DECISION DELEGATED TO DEVELOPMENT MANAGER

Application No: H14-0197-21 **Applicant:** Keston Fields Ltd
Proposal: Details of external materials (Part Condition 4 ii of H14-0355-17)
Location: Keston Nurseries Mill Green Road Pinchbeck
Terminal Date: 1st June 2021

DRAWING NUMBER: LDC2902-BR0011

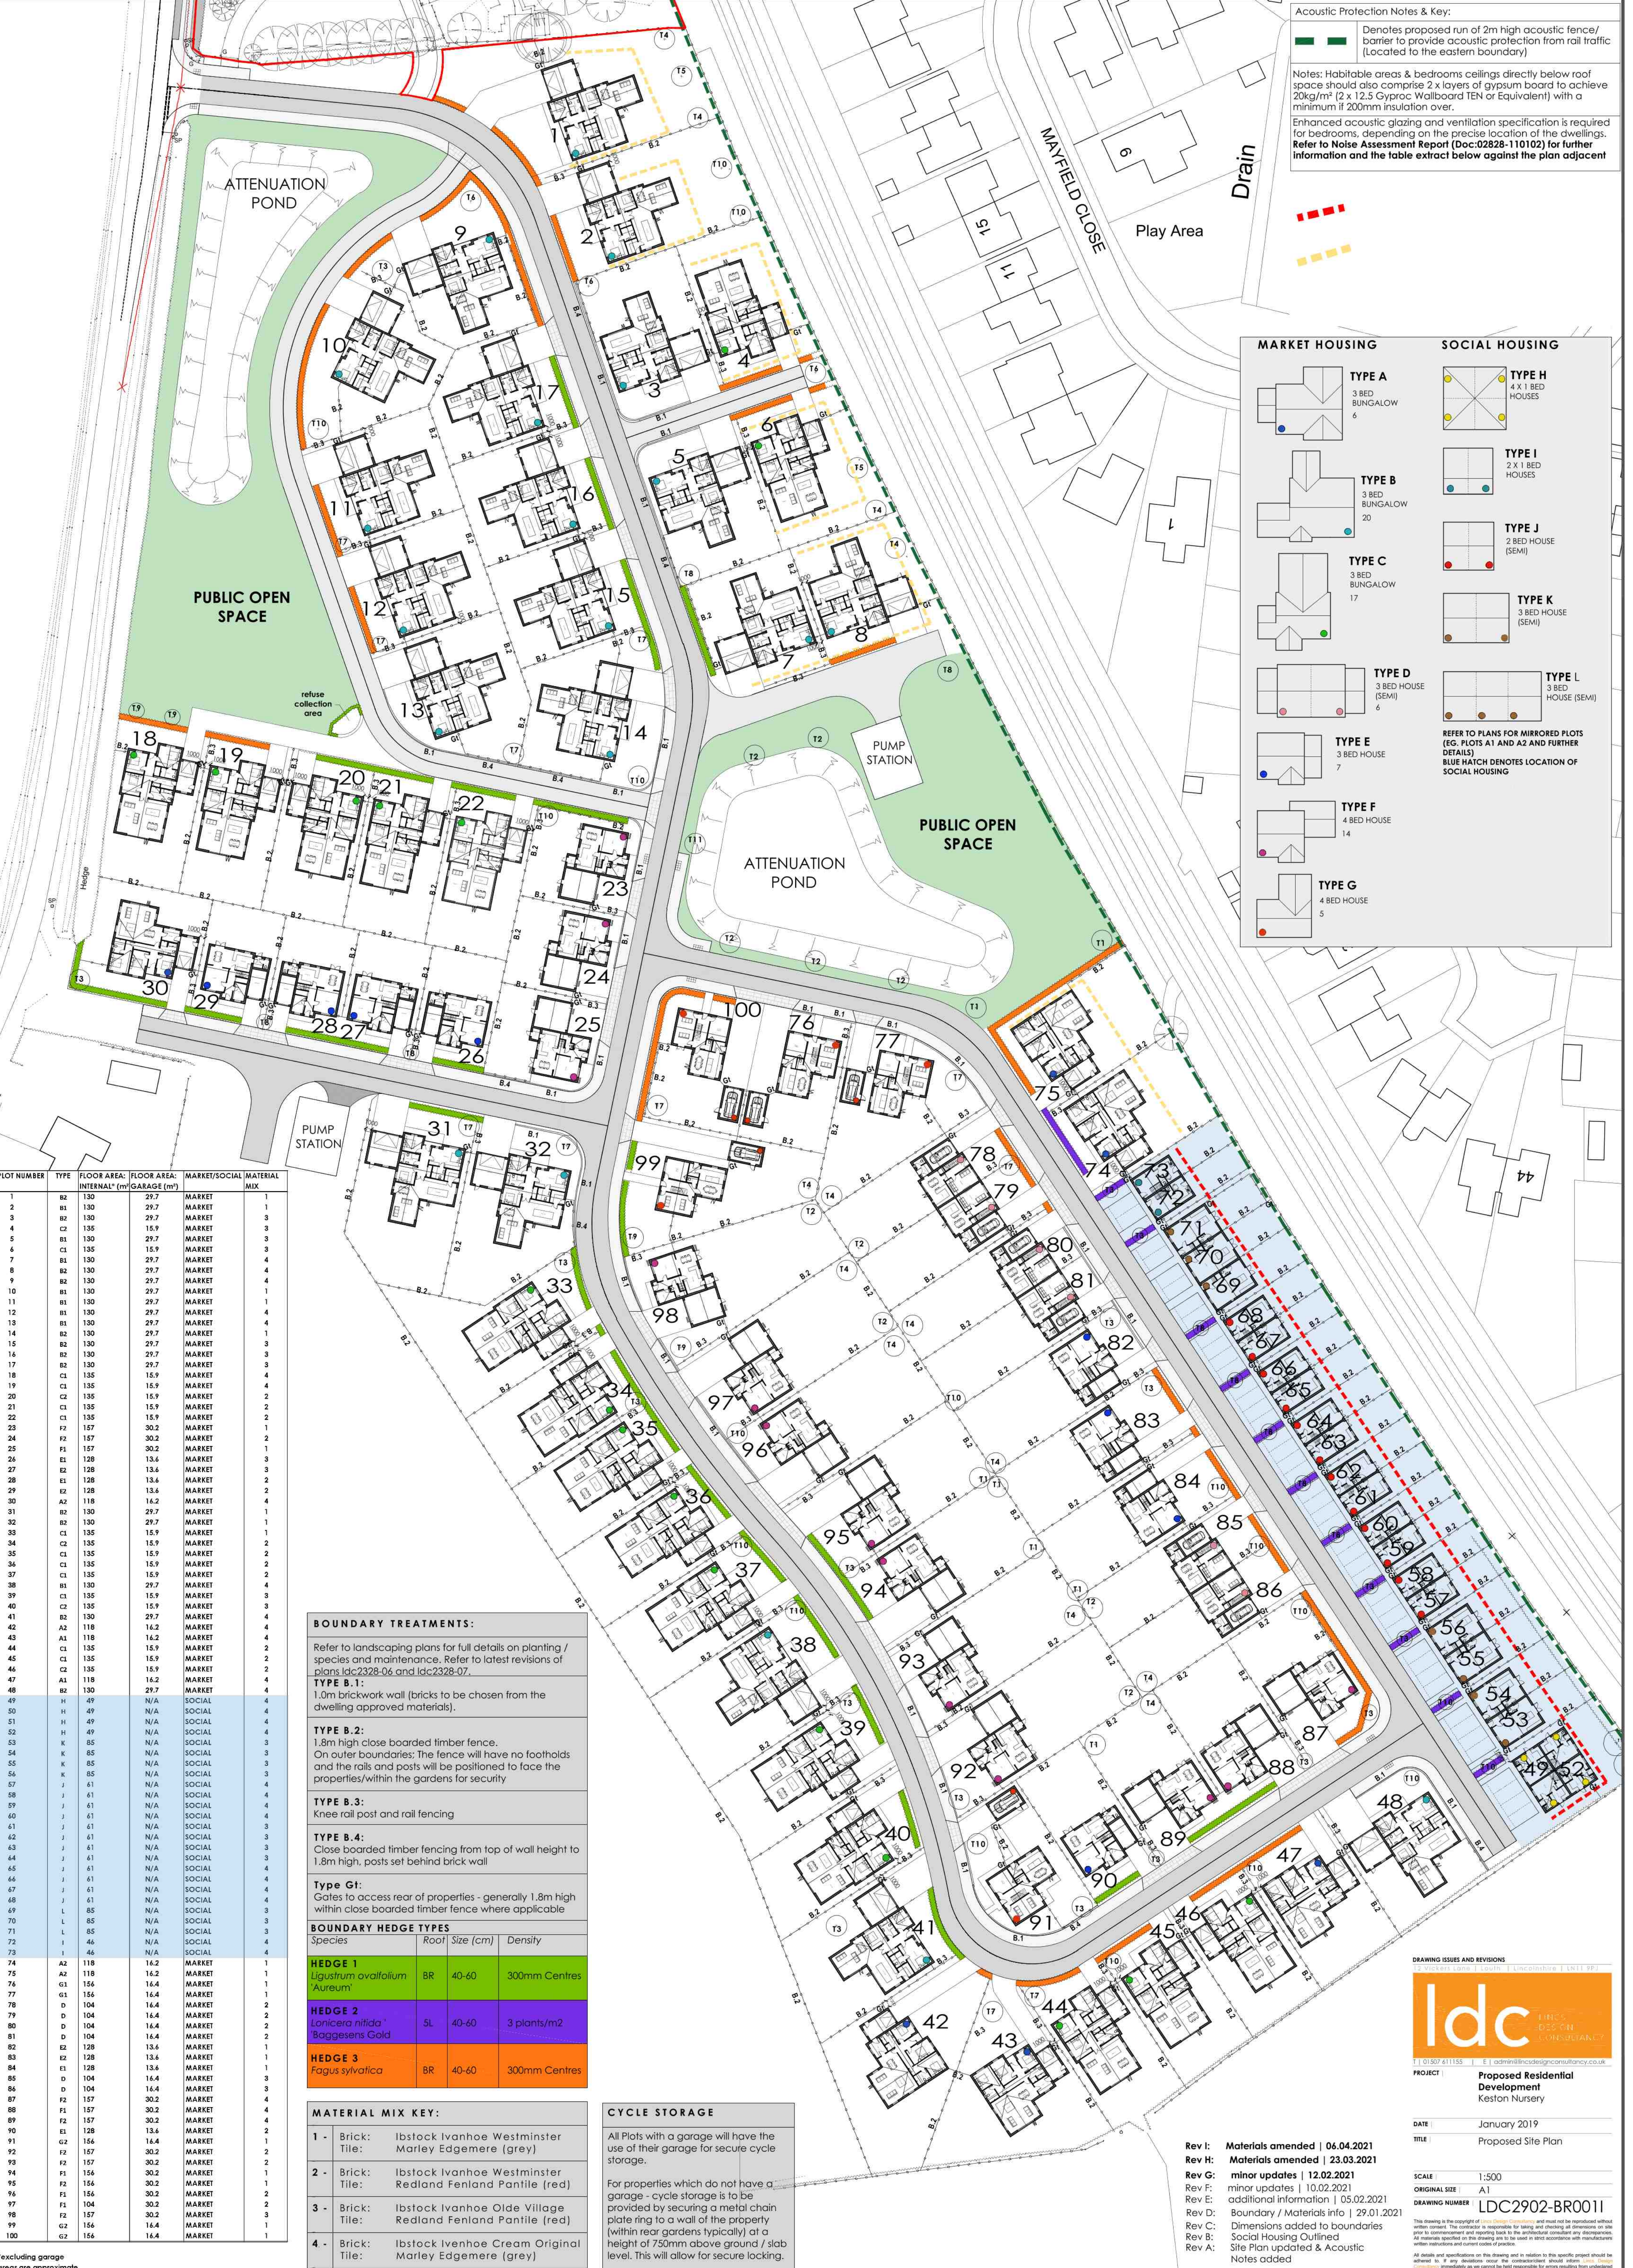
Three brick types are proposed - 2 red (Ibstock Ivanhoe Westminster and Ibstock Ivanhoe Olde Village) and 1 cream (Ibstock Ivanhoe Cream Original), at a ratio of approx 70:30. The proposed tiles are a combination of grey and red (Marley Edgemere in grey and Redland Fenland Pantile in red).

The higher percentage of red brick to be used is acceptable given the predominance of red brick in South Holland, with the bricks themselves being visually attractive. The proposed materials are therefore considered acceptable and in accordance with Policy 2 of the Local Plan. Policy 2 requires development proposals to take into account sustainable development considerations such as quality of design and impact on character and appearance of the area.
